POST EPC MEMORANDUM

TO: CABQ Development Facilitation Team (DFT)
FROM: Daniel Soriano, Planner
DATE: 01/28/2026
RE: PR-2022-007999/SP-2025-00091 – Major Amendment - Site Plan – EPC

Mitchell Associates, Inc
Landscape Architect
DANNY D. MITCHELL
239
REGISTERED LANDSCAPE ARCHITECT
Dec. 4, 2025
Copyright 2025, Mitchell Associates Inc.
PROJECT NO: 2024-055
DRAWING NO: **LS-101**

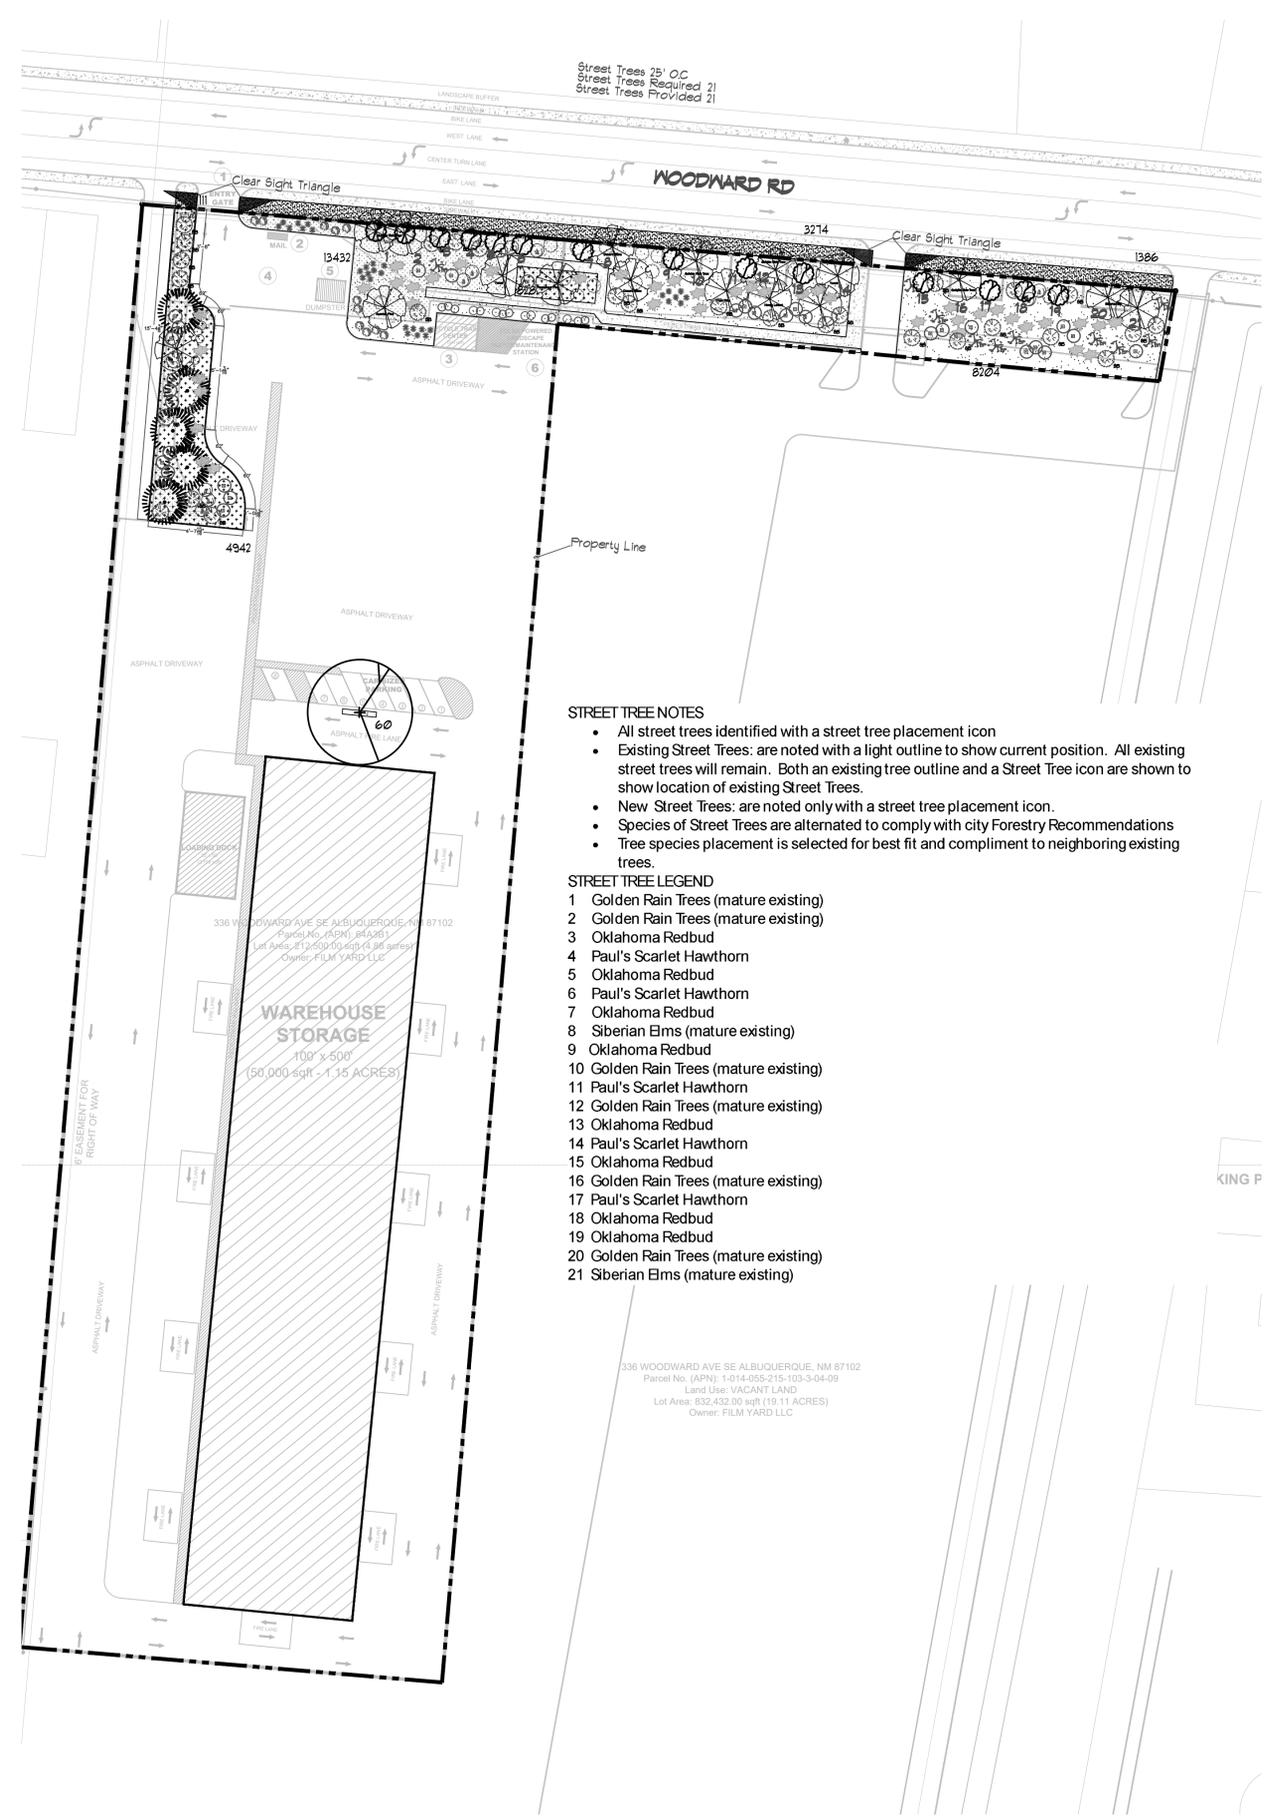
1. Landscaping sheet LS-101 shall remain the landscaping sheet for the current subject area of this request.
 - Update Total Tree and Total Shrub calculations to accurately reflect total amount of trees and shrubs that are on this sheet.
2. Re-name previous Landscaping sheet LS-101, which showed landscaping detail for lot 64A3B1 (PR-2022-007999/SI-2023-01621), to sheet LS-201.

Condition 6 has been met by the applicant: The applicant has provided updated Landscaping Plan/Sheets that accurately show the total landscaping calculations, landscaping provided, trees, shrubs for the subject area of Phases 1 and 2. The applicant has updated the landscape legend and re-titled sheets for consistency and clarity.
